**Re: SolAero Phase 2  
1600 Eubank SE  
Requested for Permanent C. O. - Accepted  
Engineers Stamp Date 8/11/16 (M21D019)  
Certification dated: 1-5-17**

**RE: SolAero Phase 2  
Grading and Drainage Plan  
Engineer's Stamp Date 8-11-2016 (File: M21D019)**

GRADING AND DRAINAGE PLAN

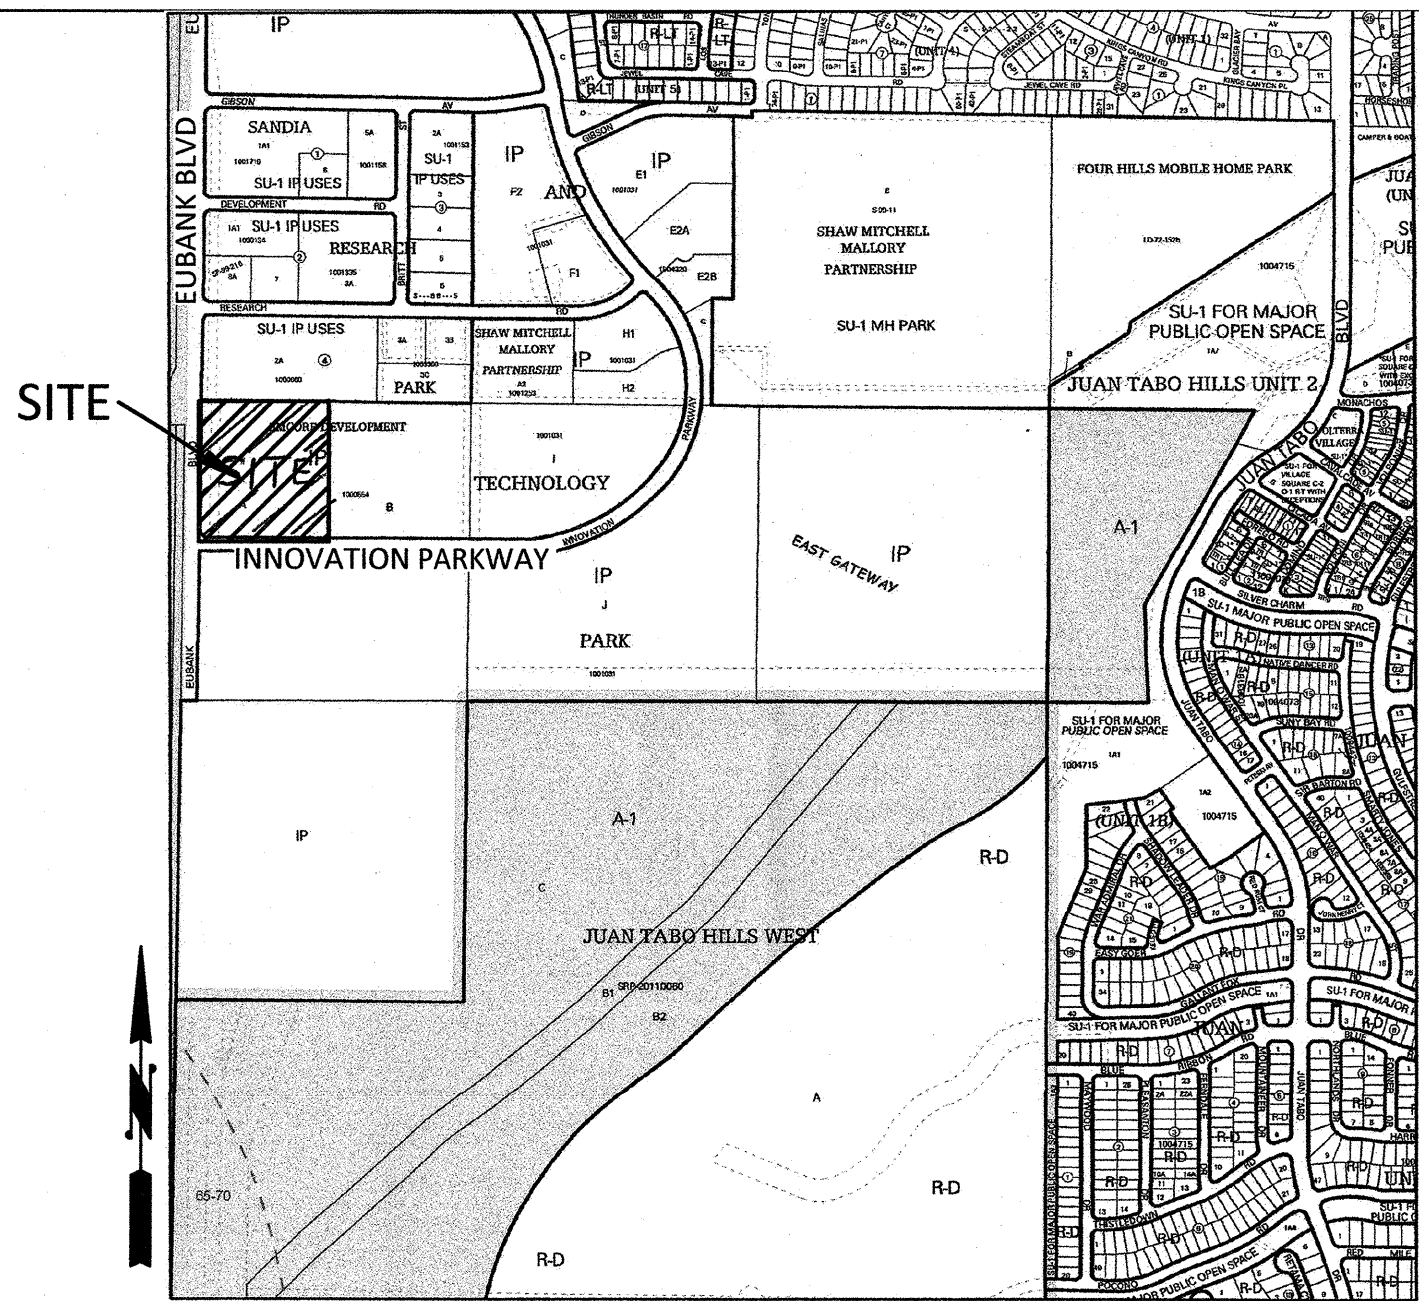
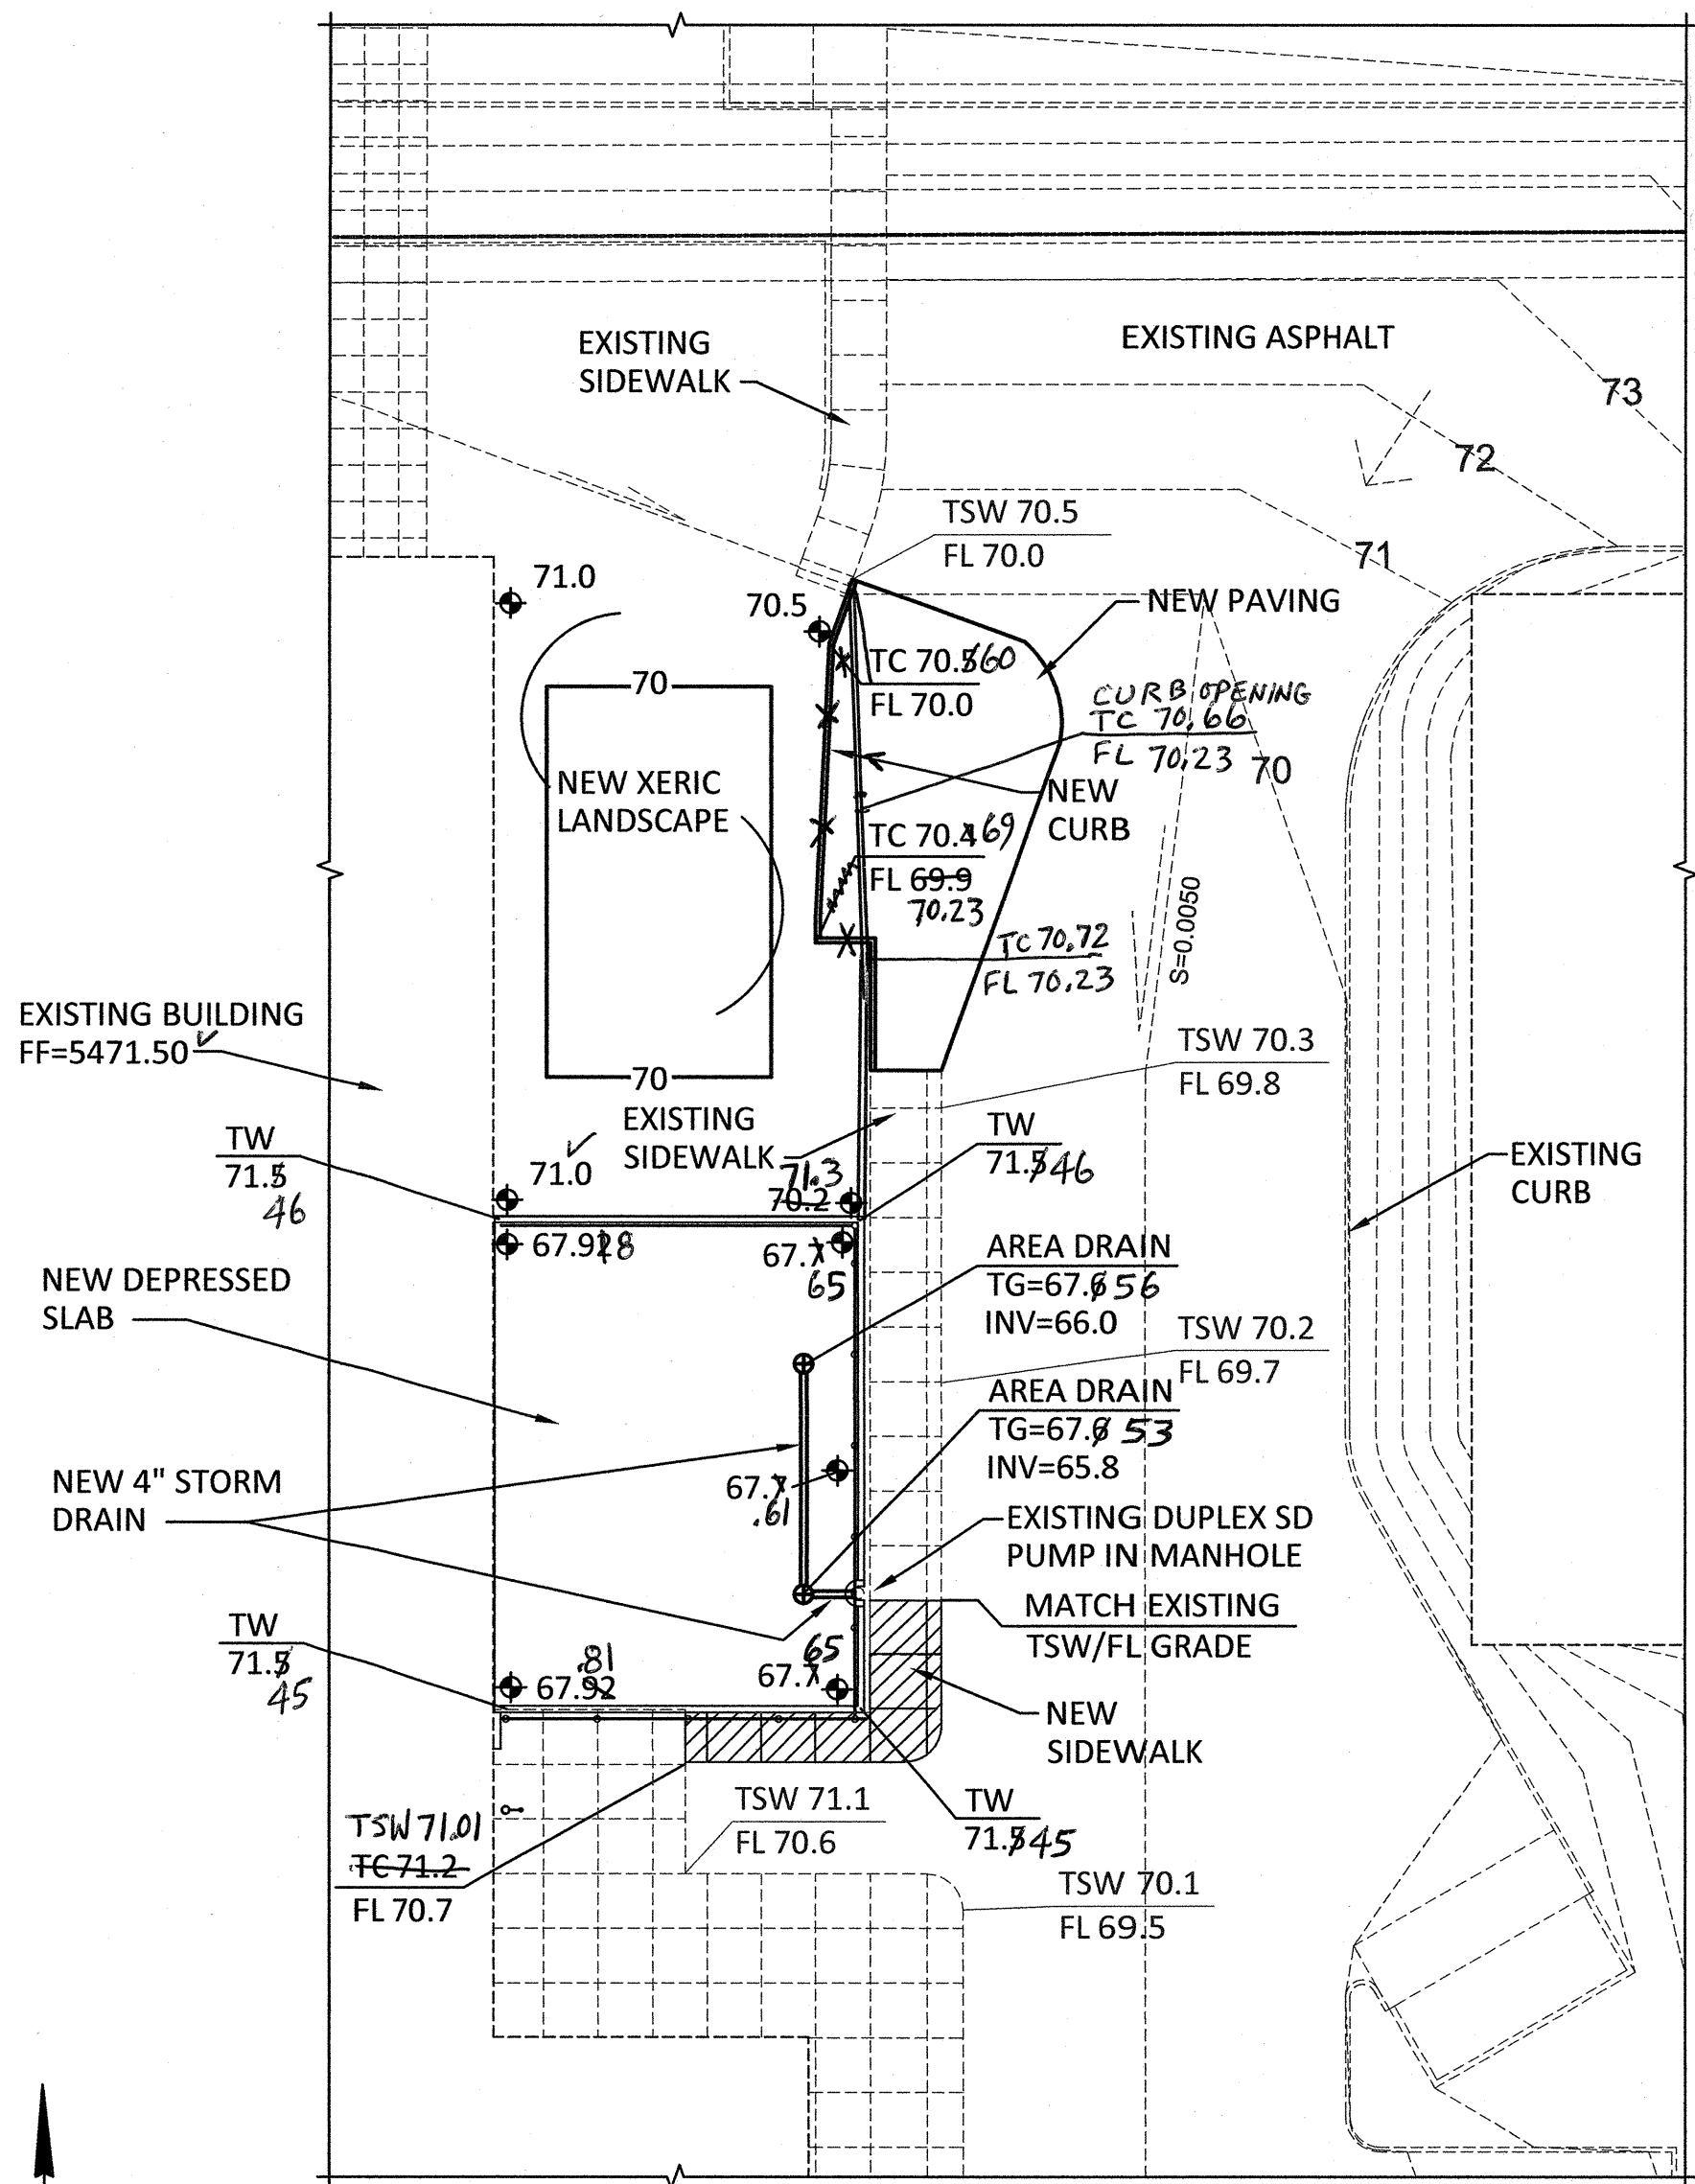
1. The pump outfall that drains the depressed slab needs to route flows under the sidewalk (sidewalk culvert or plastic pipe).
2. Ensure that the curb cuts are installed for the xeriscaped first flush area.
